**Macquarie River to Orange Pipeline Project- Orange Drought Relief Connection
(Application no. 10_0235)**

**Appendix G- Aquatic Ecology. Environmental Assessment and the impact on
native fishes**

Figure 3: Proposed position of the offtake structure, pumps and associated infrastructure at MR5a on the southern bank of the Macquarie River (Source: MWH).

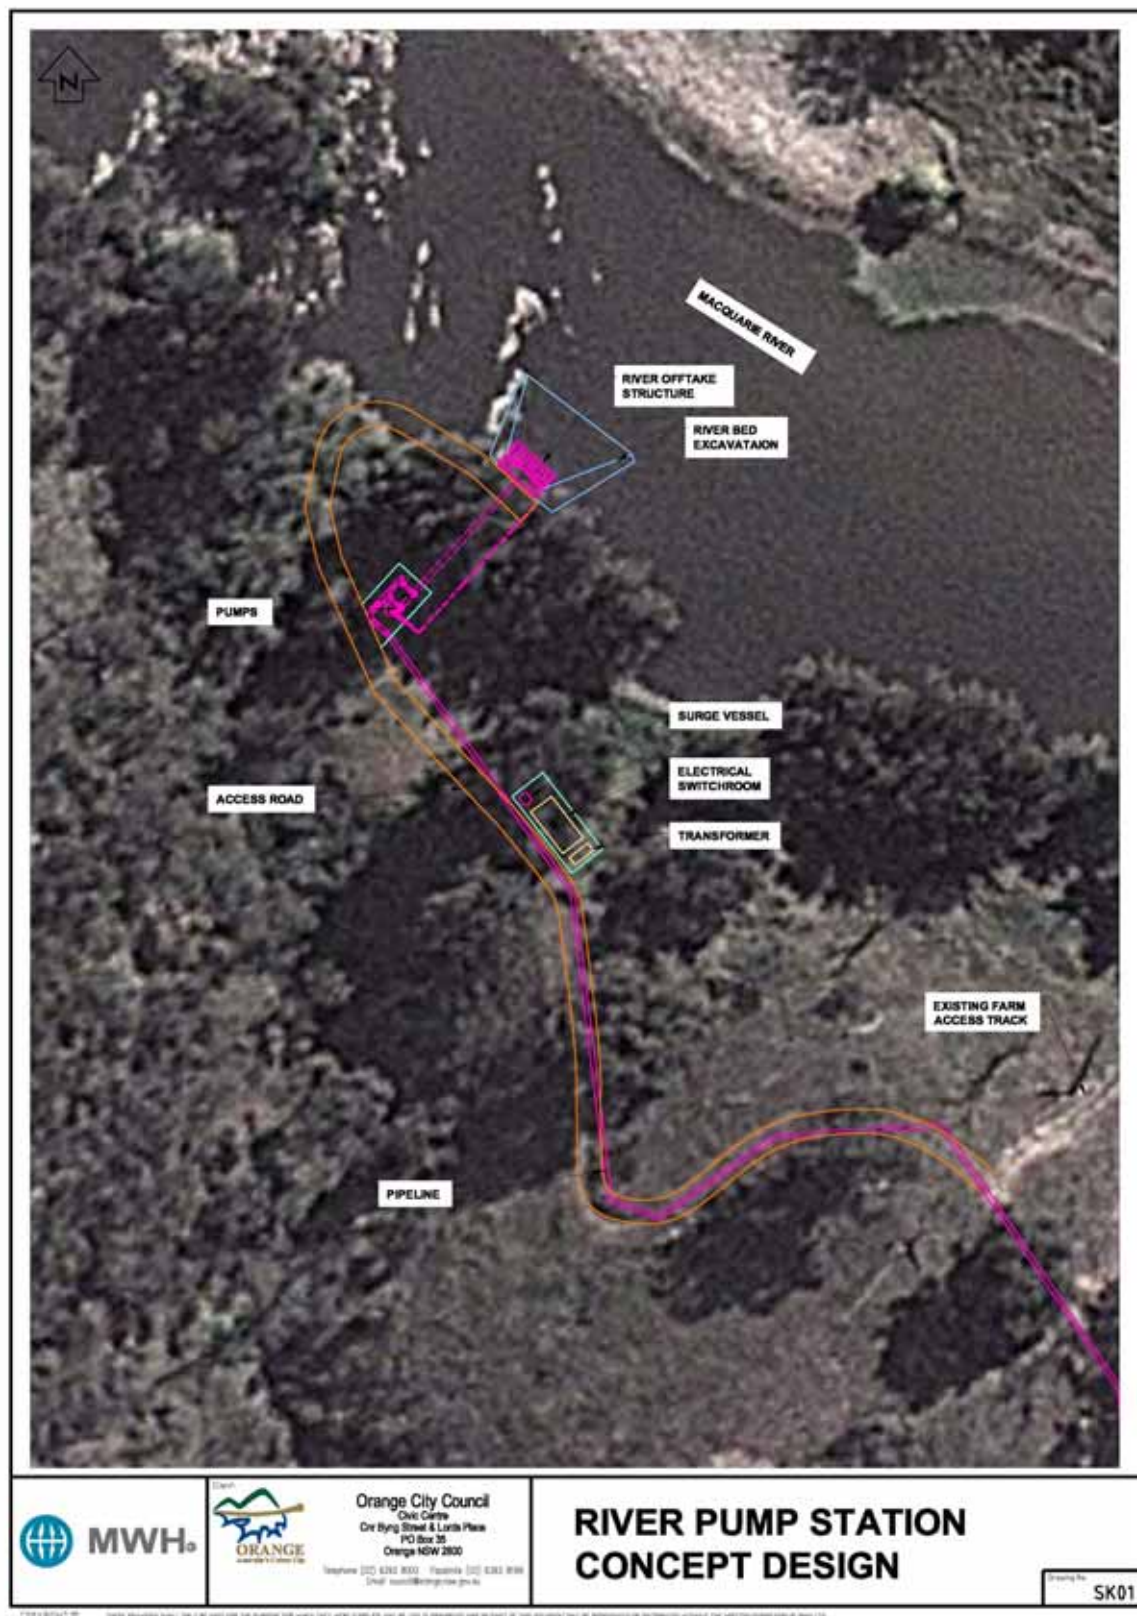
The aquatic assessments conducted by Cardno and GHD indicated that “native fish are scarce” in the Macquarie River around the proposed pump location. However, the lack of native fish reported in these surveys appears to be a reflection of 1) the limited amount of sampling conducted during the surveys and 2) the use of inadequate methods that were used to sample the habitat available at the proposed off-take site.

Given the size and depth of the water holes in this area, back-pack electrofishing (which was the main technique used in the assessments) would only sample a minor proportion of habitat that is available in each water body as it is restricted to waters below about waist height. Much work has been done in Australia over the past 15 years to develop protocols for the assessment of riverine fish communities, this includes protocols within the Sustainable Rivers audit (SRA) and others commonly used by state government departments (e.g. NSW Rivers Survey and the Victorian Environmental Flows Monitoring and Assessment Program). These protocols often require boat electrofishing to be utilised in all navigatable habitats (e.g. any waters deeper than 0.75m or waters deeper than those that can be sampled with a back-pack electrofisher). While it is unrealistic to expect all consultants to have access to specialised boat electrofishing equipment, if this equipment was not available, other methods could be used effectively in order to better sample these habitats. For example, more thorough netting than that used in the current surveys or even structured angling surveys would give a reasonably comprehensive overview of the species present and their relative abundance.

When the location of the catch is examined, it can be seen that the majority of fishes are coming from the proposed pump hole (known as Gardiners) or from the holes immediately below it (known as Pumkin, Dick Burk and Boathole) (Figure 2). This further suggests that the waters most likely to be effected by the proposed pipeline are important habitats for native species. Other anglers also maintain records and photographs (with local land marks in the background to verify the capture location) for native fish captures in the area (including from sites above the pump hole) and these have not been included in the data presented below. This also includes recent records (and photographs) of the endangered trout cod (*Maccullochella macquariensis*).
